Meeting note

Project name	A417 Missing Link
File reference	TR010056
Status	Final
Author	The Planning Inspectorate
Date	17 May 2021
Meeting with	Highways England (the Applicant)
Venue	Microsoft Teams
Meeting objectives	Project update
Circulation	All attendees

A417 Missing Link – TR010056

Section 51 advice regarding draft application documents submitted by Highways England

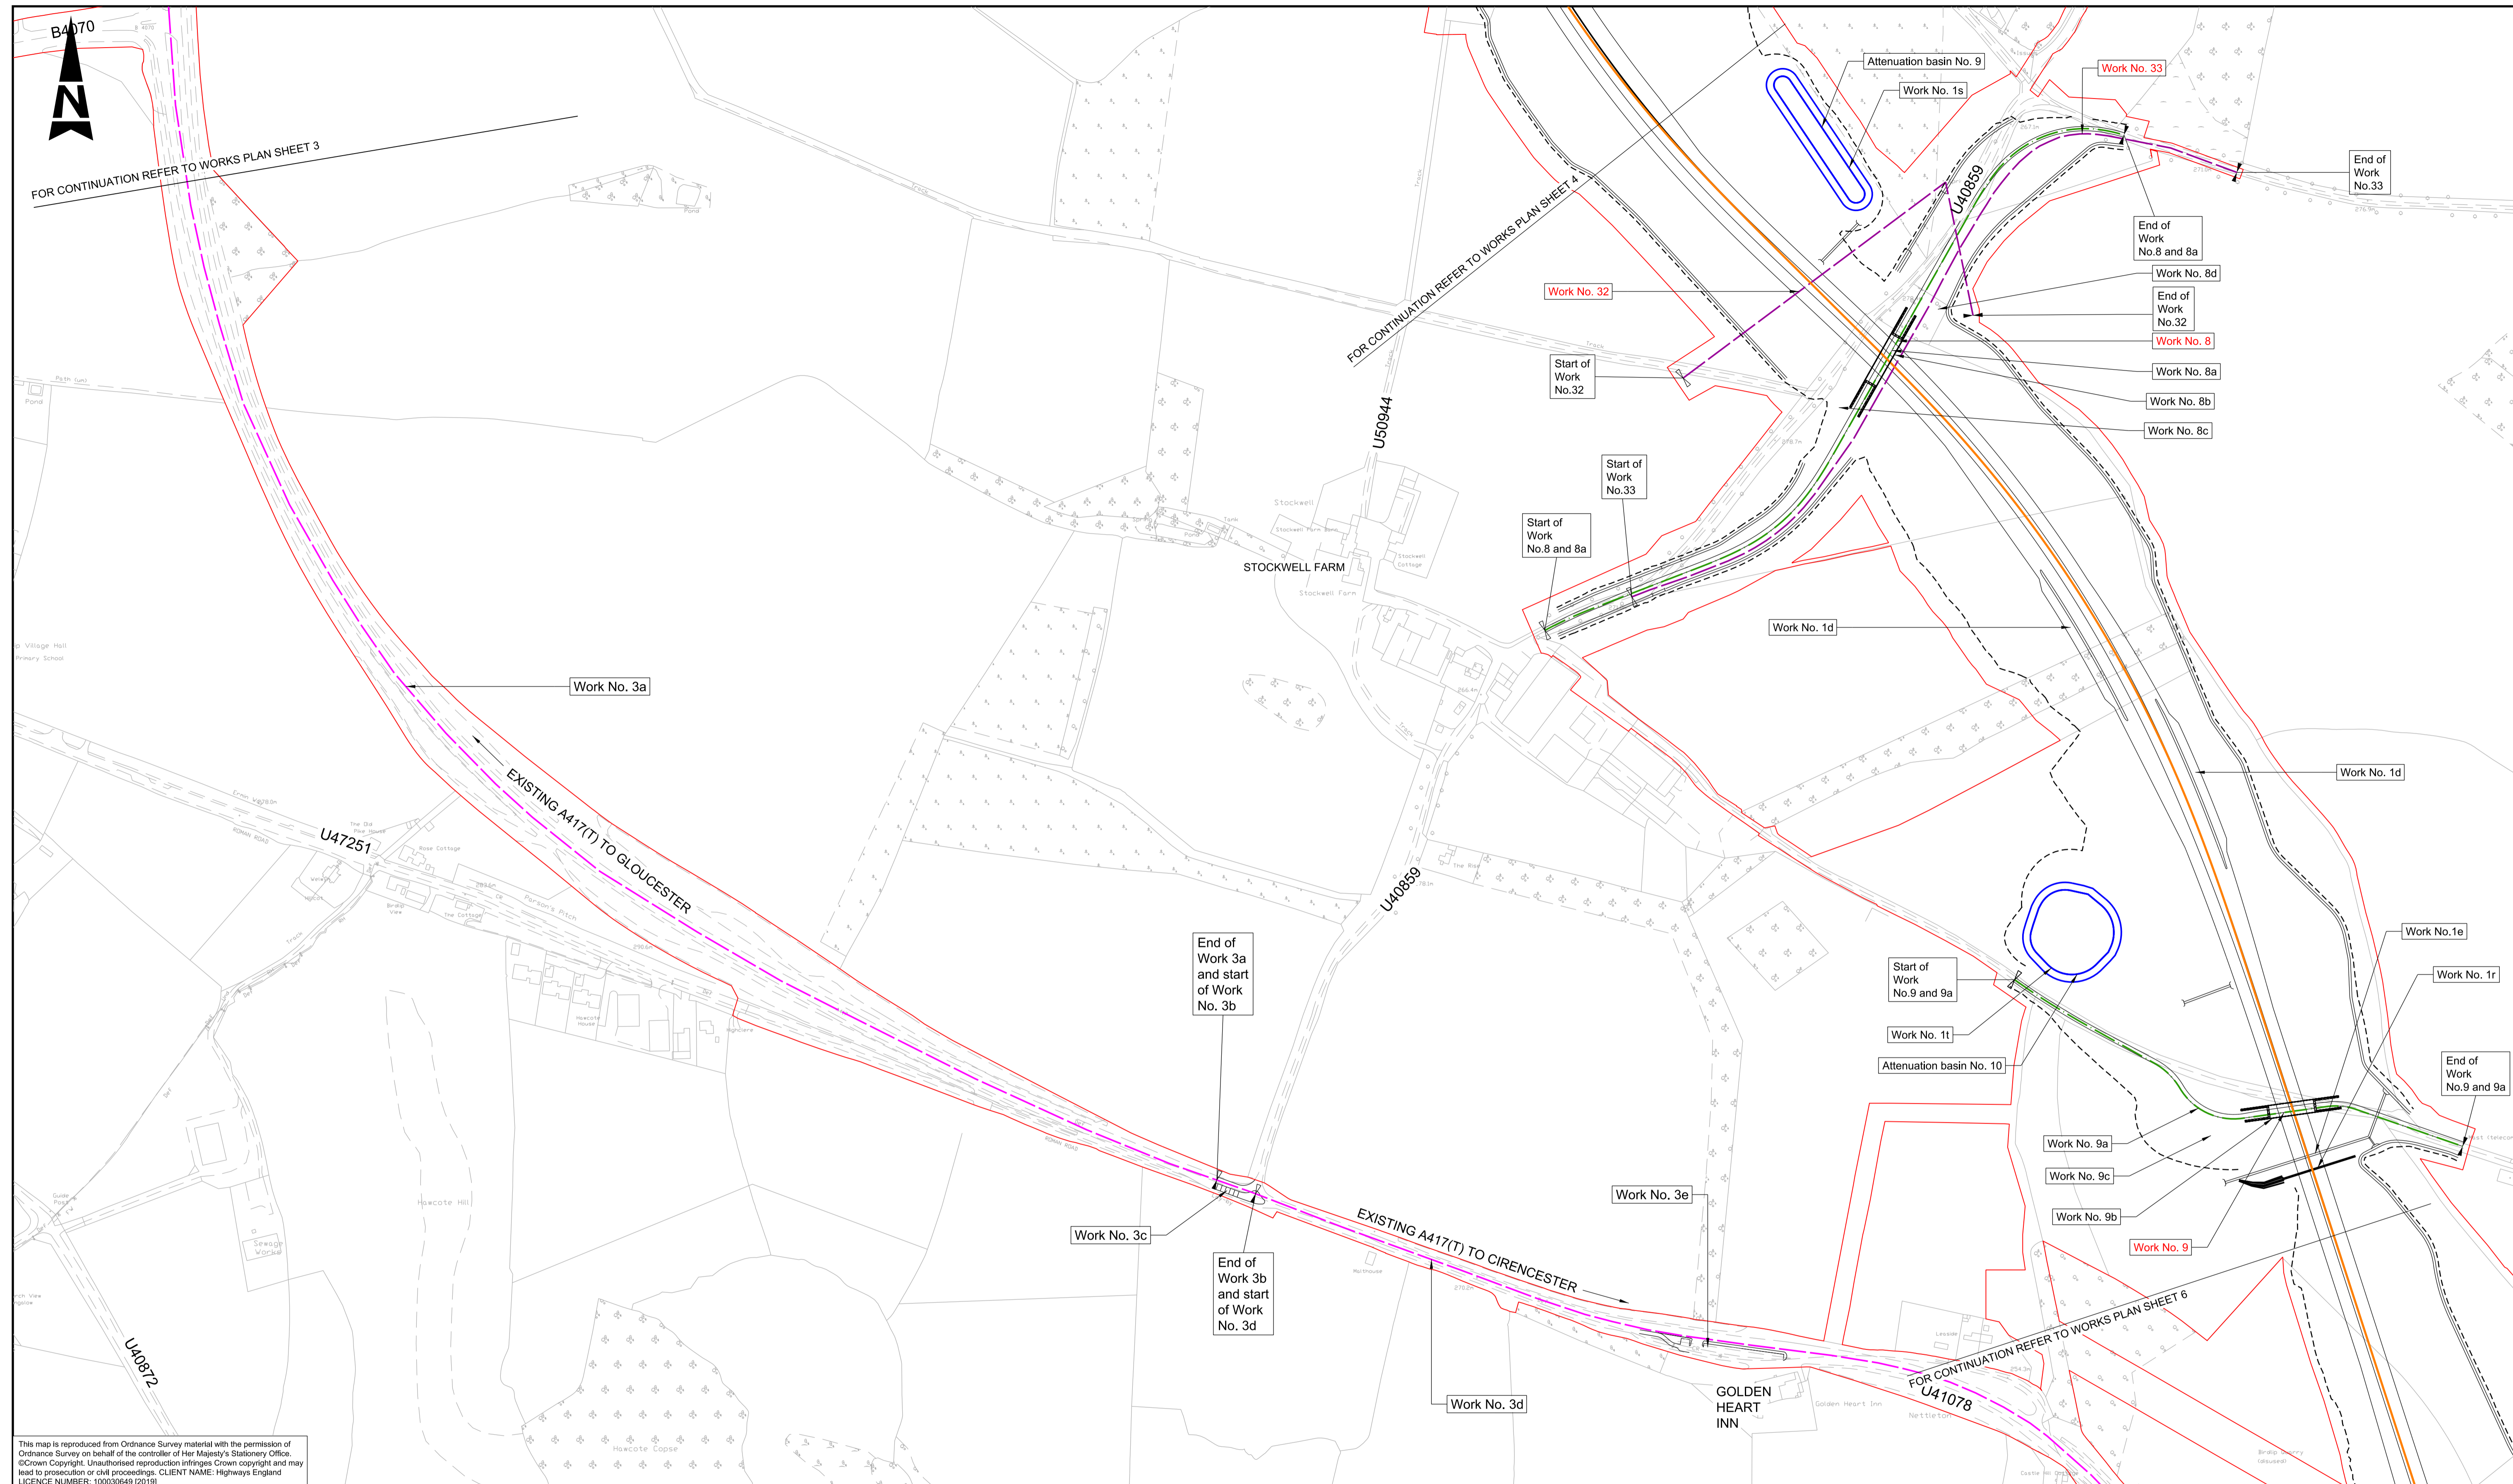
46.	Sheet 4 of 6	There are two 'Point G' annotations on Sheet 4.
47.	Sheet 6 of 6	Regarding Sheet 6, the Inspectorate notes: <ul style="list-style-type: none">Schedule 3, Part 4 of the dDCO describes points 34 and 35 as "<i>Realigned A417(T)</i>", however this is illustrated on Sheet 6 by a black line which the key identifies as "<i>New unclassified roads</i>".

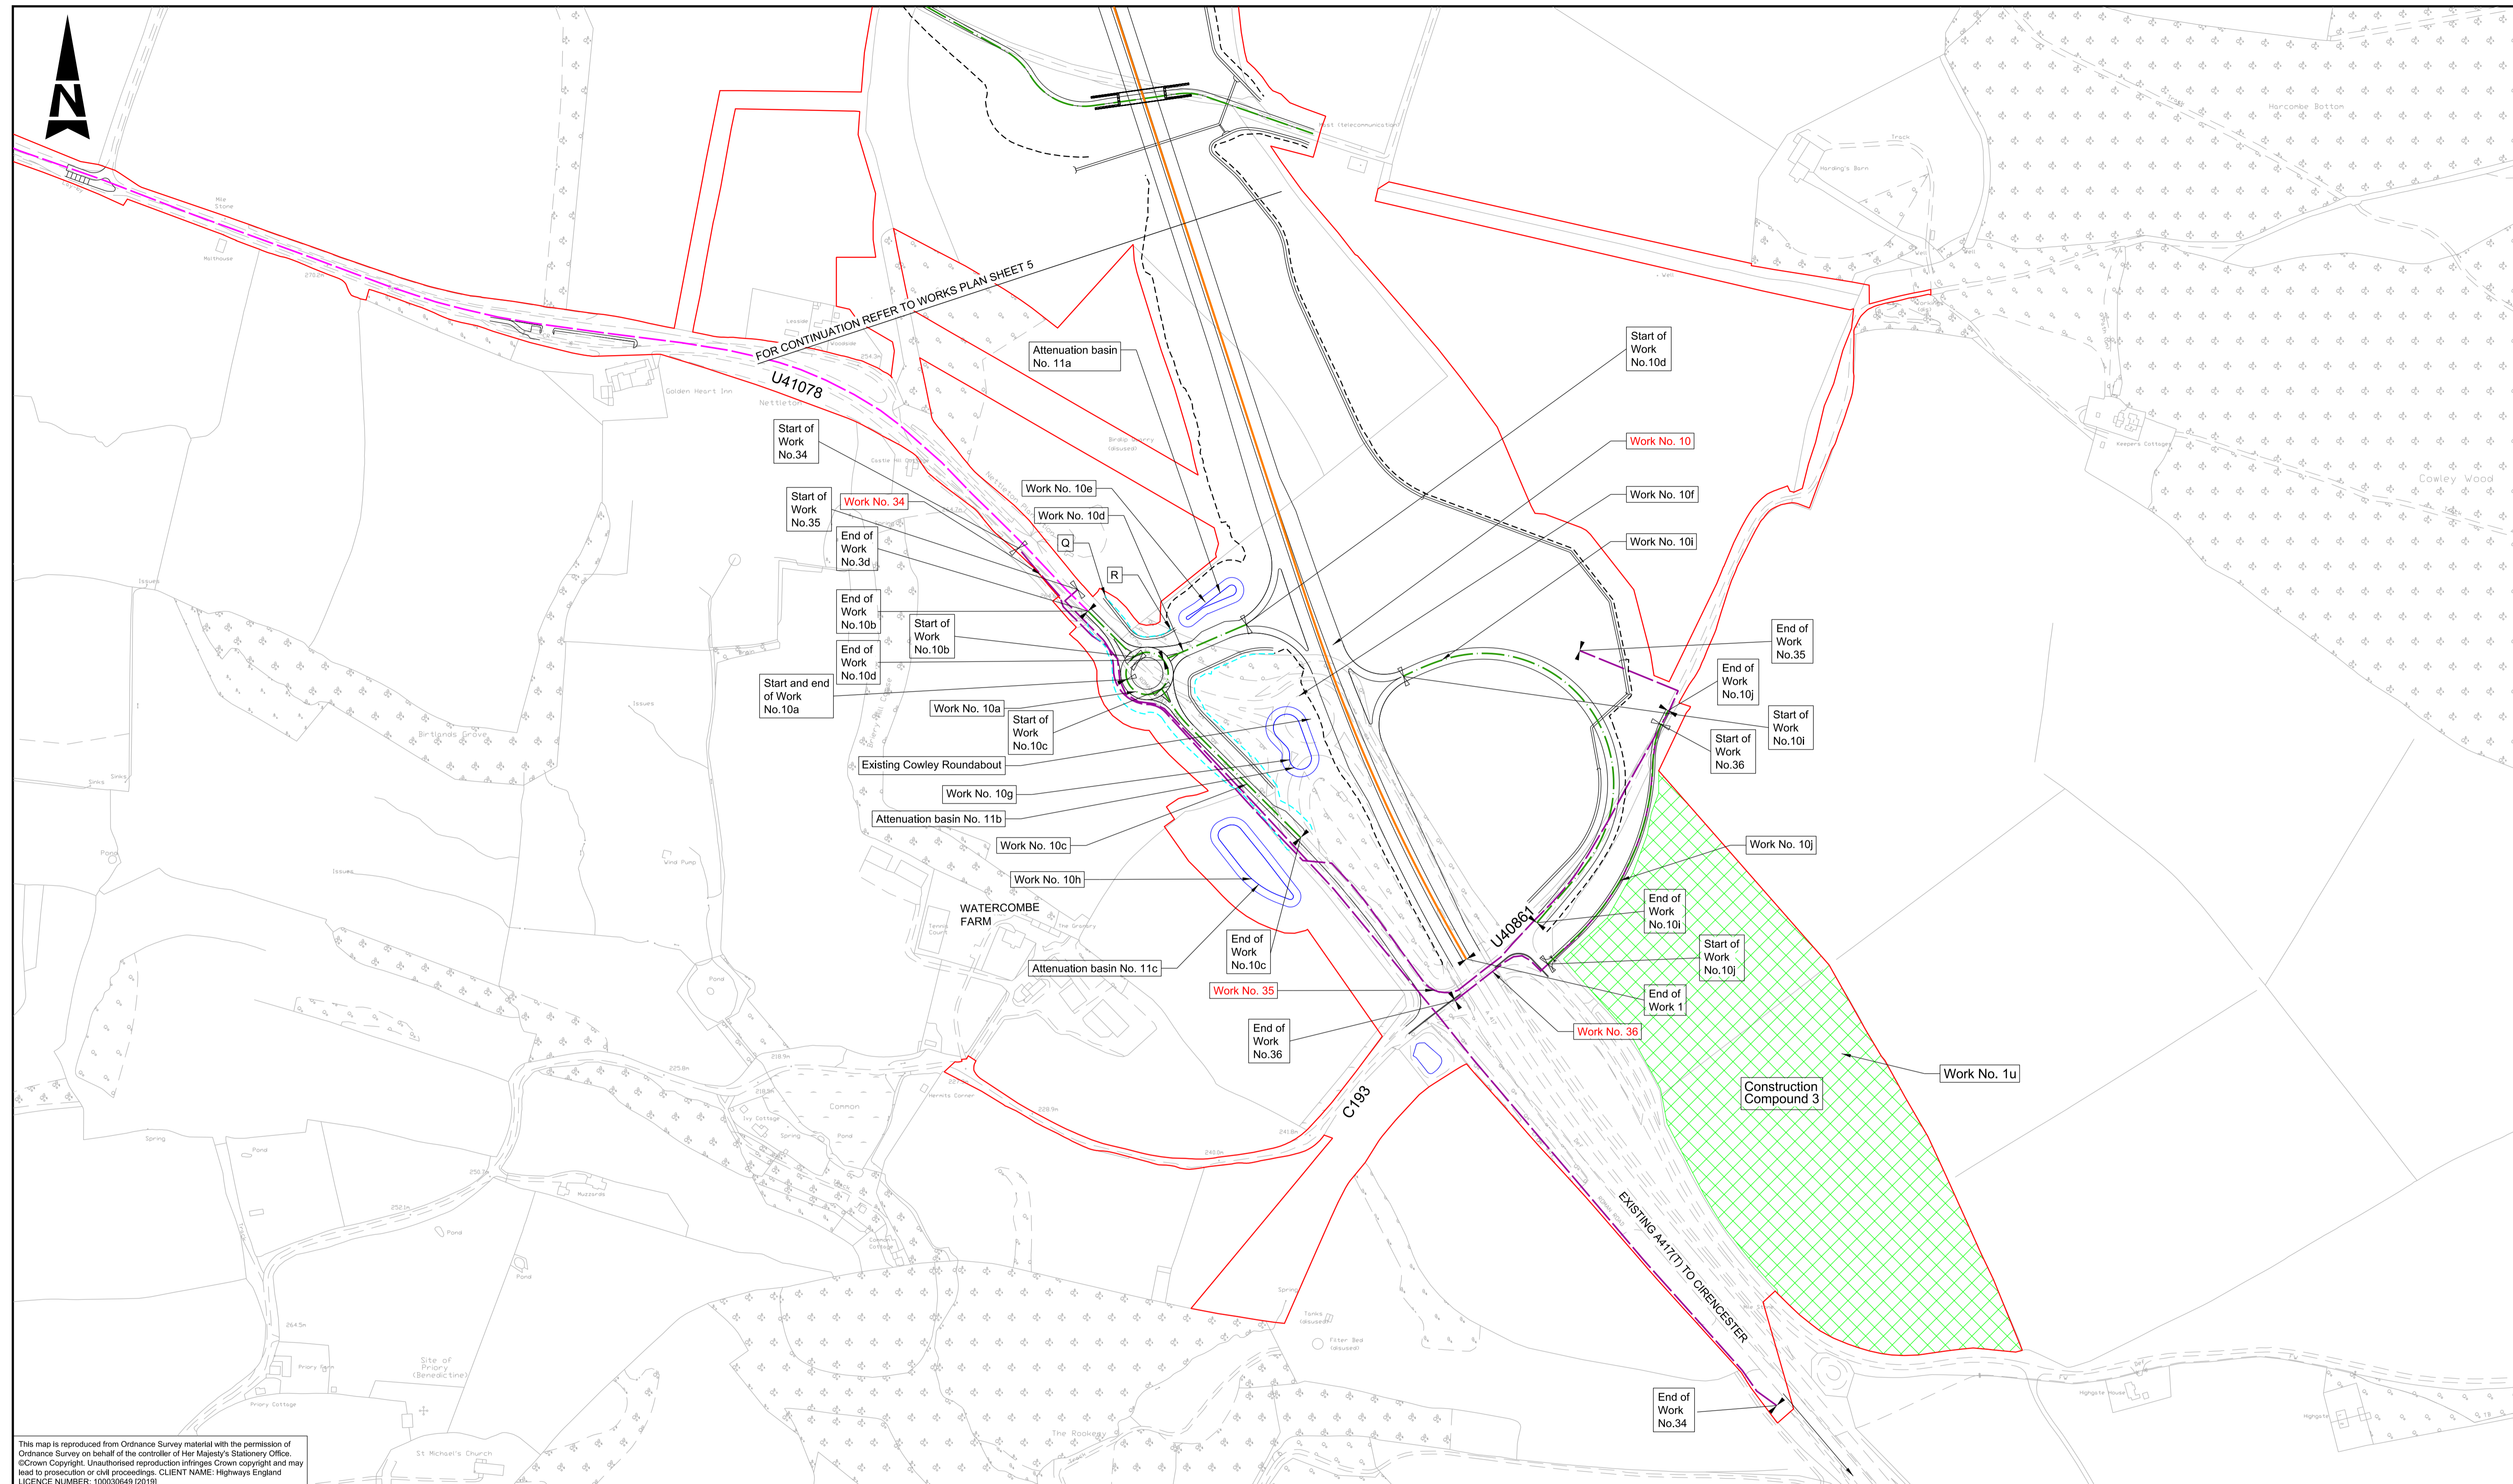
Draft Works Plans		
Ref No.	Work Plan Ref	Comment/Question
39.	Sheet 5 of 6	Car parks are not illustrated consistently eg see Work nos. 3e and 3c.
40.	Sheet 3 of 6	Regarding Work no. 16, it would be useful for the utilities centreline on the top of the sheet to be labelled for ease of reference. Given that this work is also shown on Sheet 1, should there be a continuation from Sheet 3 to Sheet 1?
41.	Sheet 2 of 6	Regarding Work no. 20, the linear power cable diversion work shown on Sheet 2 has no centre line and has no end point, so it is unclear what route the work follows and where it ends. It overlaps with Work no. 7k which makes it even less clear. The Applicant is advised to consider how to present these works in a way that is clear and reliable for the examination.
